From: Amanda Scholes on behalf of Planning.Responses
Sent: 17 August 2018 12:09
To: Planning Scanning
Subject: FW: Planning Application: FG/105/18/PL - Asda, Littlehampton Road, Ferring Worthing.
Attachments: 11-046-C11 X.pdf; 11-046-C10 X.pdf; 11-046-C01 X.pdf; 05.16049-ACE-00-XX-DR-D-50-0101-P06-Proposed Drainage Layout.pdf; ASDA Ferring 18 08 18 storage inc entrance road.pdf
Importance: High

From: Paul Gill [REDACTED]
Sent: 18 July 2018 12:30
To: Laura Gibbons
Cc: Andy Clifton; Brad Wiseman; Chris Hill; Richard Sanderson; Tony Murray; Adam Slade
Subject: Planning Application: FG/105/18/PL - Asda, Littlehampton Road, Ferring Worthing.
Importance: High

Title
Tank Farm general
arrangement

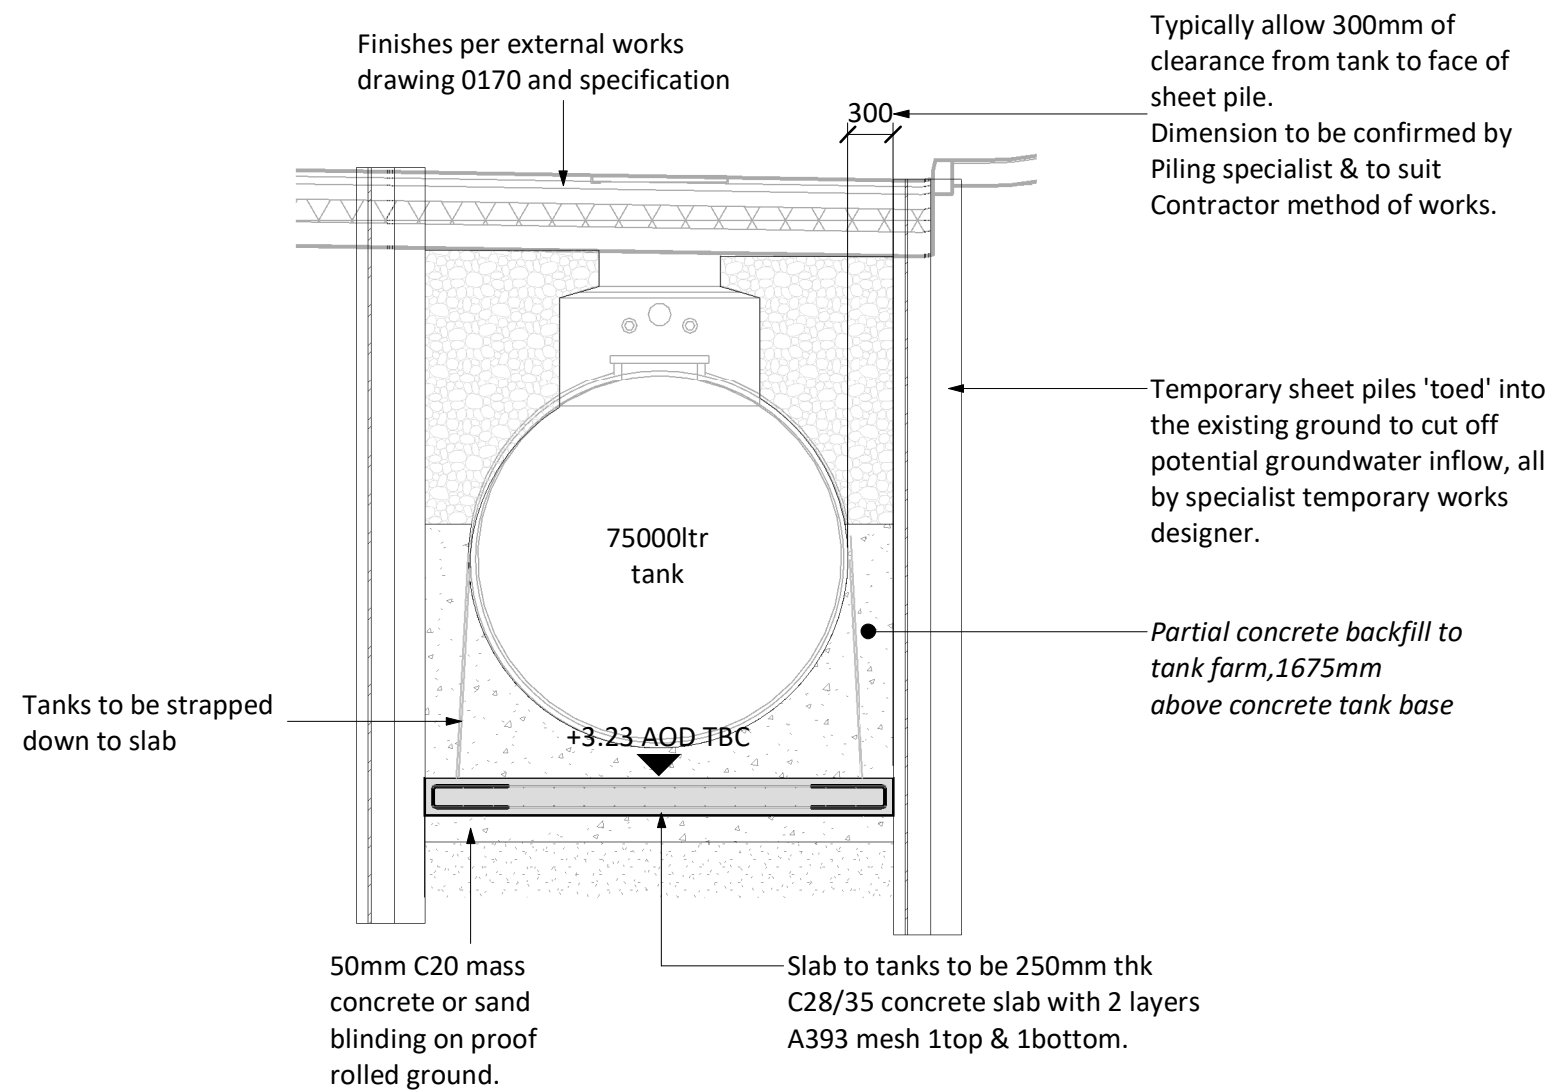
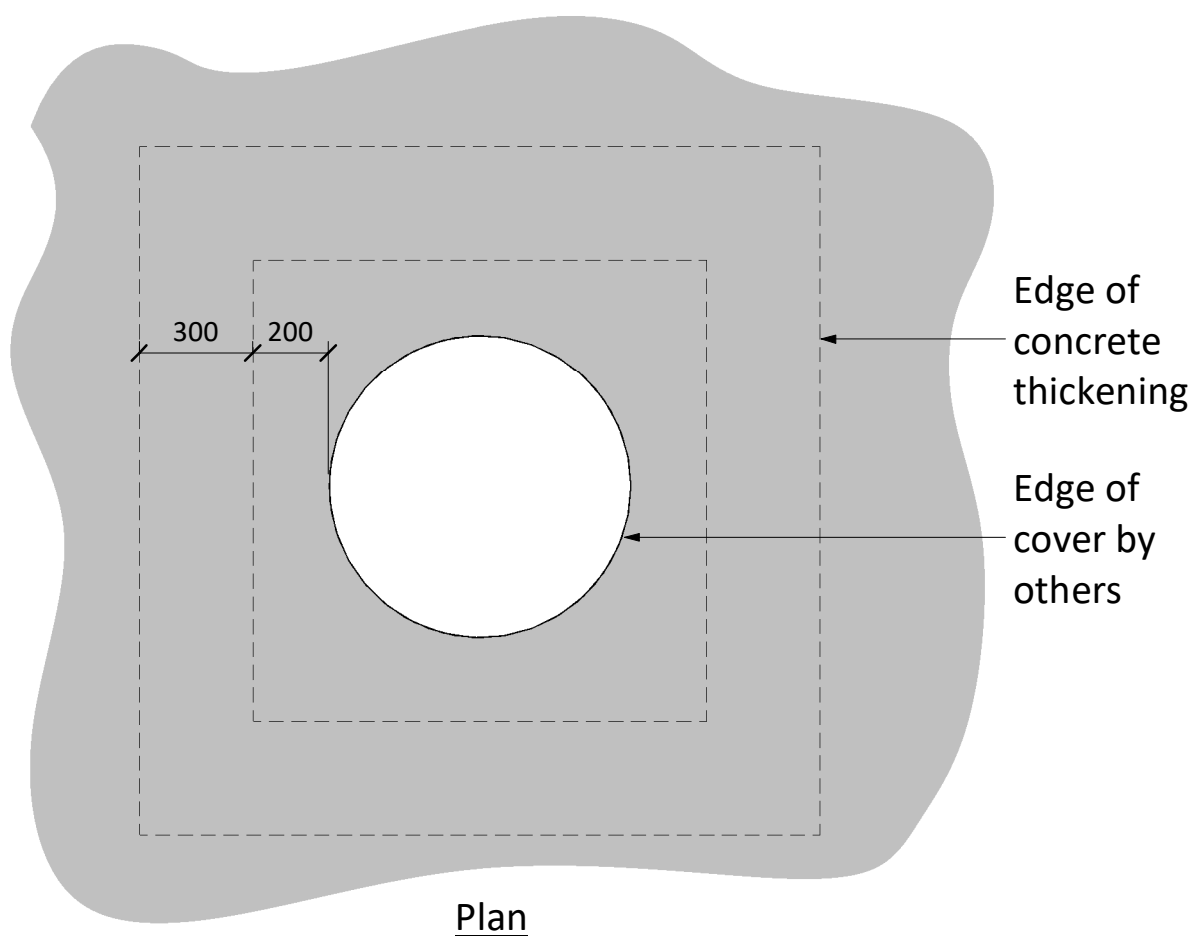
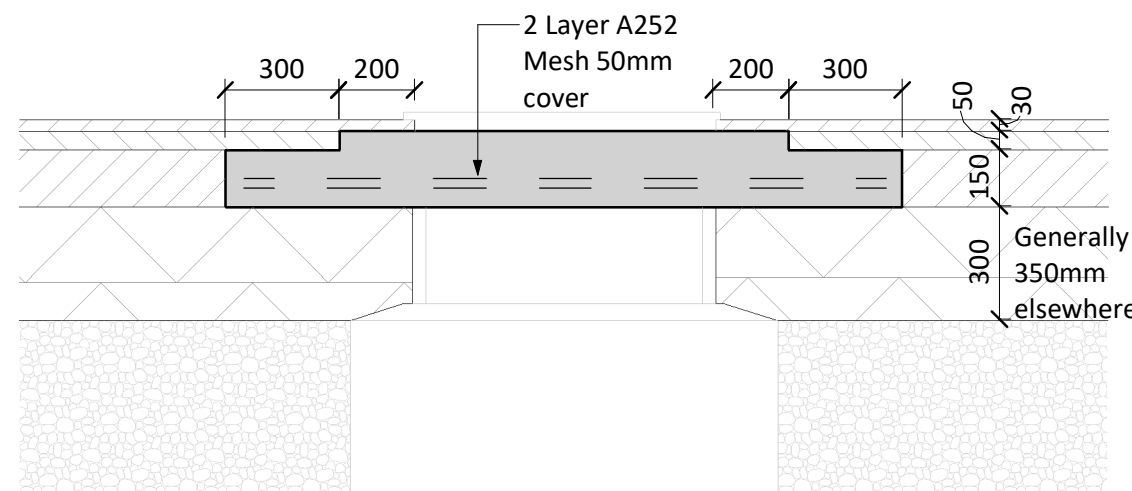
I would like to see calculations showing the new proposed system and the as built system. As the hydro brake is already being used it is currently unclear if there is sufficient capacity for both systems to work together.

I will require further construction detail drawings showing the attenuation tank, hydrobrake, pipe protection details, manholes and catchpits. I will also require calculations proving the design meets our requirements in terms of storage and half drain time.

1. Construction details of the tank are shown on our drawing 102 Rev P1 – Attached. This will be a sealed system and now allowed to soakaway.
2. Hydrobrake – The Hydrobrake is existing in manhole EX01, we are not proposing for this manhole to change. Rating is 5 l/s.
3. Pipe protection details – Drawing 102 Rev P1 shown examples of concrete encasement for pipe protection.
4. Typical manhole detail is shown on drawing 102 Rev P1.
5. I attach micro drainage calculations for the attenuation proposed on site at discharge rate of 5 l/s.
